Steepleton Lodge Barn, Long Lane, East Haddon, Northamptonshire, NN6 8DU

To: **Brenda Vandamme** From: **Rachel Canham**  
Company: - Date: **26 August 2016**  
Email: [Redacted] Ref: **4214**  
Copies to: [Redacted] Page: **1 of 5**  
Subject: **Swalcliffe Park Equestrian – Comments on application to amend condition 5 of the planning permission**

### Summary

Sound pressure level of sound source (measured at 1m) versus required distance from dwellings at the site boundary

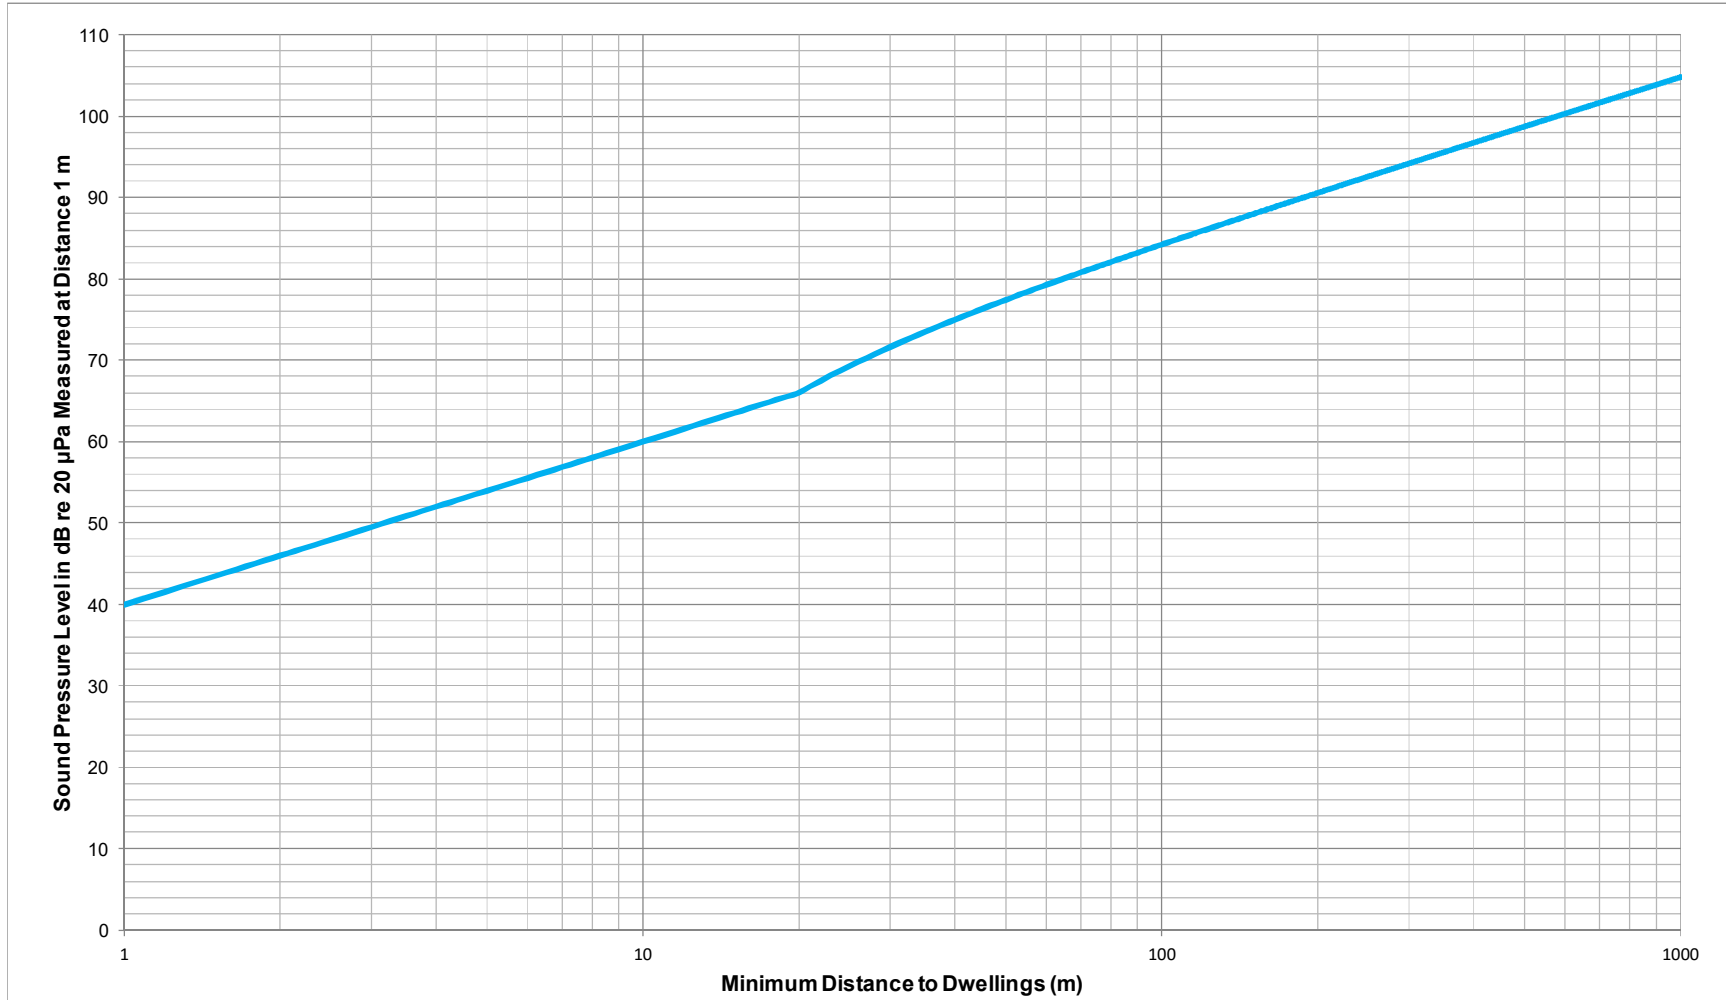
Appendix B of the revised NMP provides a chart of noise levels against distance. The chart is intended to result in a level of 40 dB  $L_{Aeq,T}$  at the relevant distance, which at first glance would appear to result in a better situation than the current 45 dB  $L_{Aeq,15min}$  limit at the dwellings.

However, I am concerned that the implementation of this chart will require considerable input from the organiser and also that the approach does not take into account cumulative noise levels, meteorological corrections.

It is noted that the chart provided in Appendix B of the revised NMP appears to include an allowance for attenuation in addition to that due to distance, possibly due to air and/or soft ground, but has not included any allowance for meteorological effects i.e. is the wind is blowing towards the dwelling from the site. ISO 9613-2 indicates that (for distances of around 500m) meteorological corrections could be up to 5 dB, although values in excess of 2 dB are exceptional.

Cumulative effects of multiple sources are also mentioned in Appendix B but are dismissed as insignificant on the basis that sound sources are located "suitably far apart" although this distance is not defined. There are no stated requirements for PA loudspeakers or other sources to be spaced "suitable far apart" and in addition, even if these sources were spaced apart from each other, they could still be equidistant from a dwelling meaning that multiple noise sources could contribute to the overall noise level.

There are no stated requirements for the noise measurements of the PA loudspeakers and plant items to be in the dominant noise direction or at an appropriate height to be representative of the source output. Without these, the revised wording of the Noise Management Plan could mean that the measurements are open to abuse, as noise levels could be measured in any direction and at a lower height than the source output. This could result in higher than expected levels occurring at the dwellings. In addition, there does not appear to be any minimum standard required for the instrumentation used to determine these limits, nor the parameters that need to be recorded.

Furthermore, the implementation of this chart will require considerable input from the organiser. The organiser will need to check the distance of every PA loudspeaker and item of plant from each dwelling. Using these distances, the organiser would then need to read off the appropriate noise limit at 1m for each loudspeaker and item of plant from the chart. The chart is presented with a logarithmic range for the distance which is not necessarily easy to read. The noise level generated by each loudspeaker and item of plant will then need to be checked against the pre-determined limits by noise measurement. Note my comments above about the measurement direction, height and instrumentation requirements of these readings.

As the layout of each event is variable with loudspeakers and plant items at different locations, this will need to be repeated for each scenario. It is realistic to expect that the organiser will complete this detailed assessment for every loudspeaker and plant item position for each event?
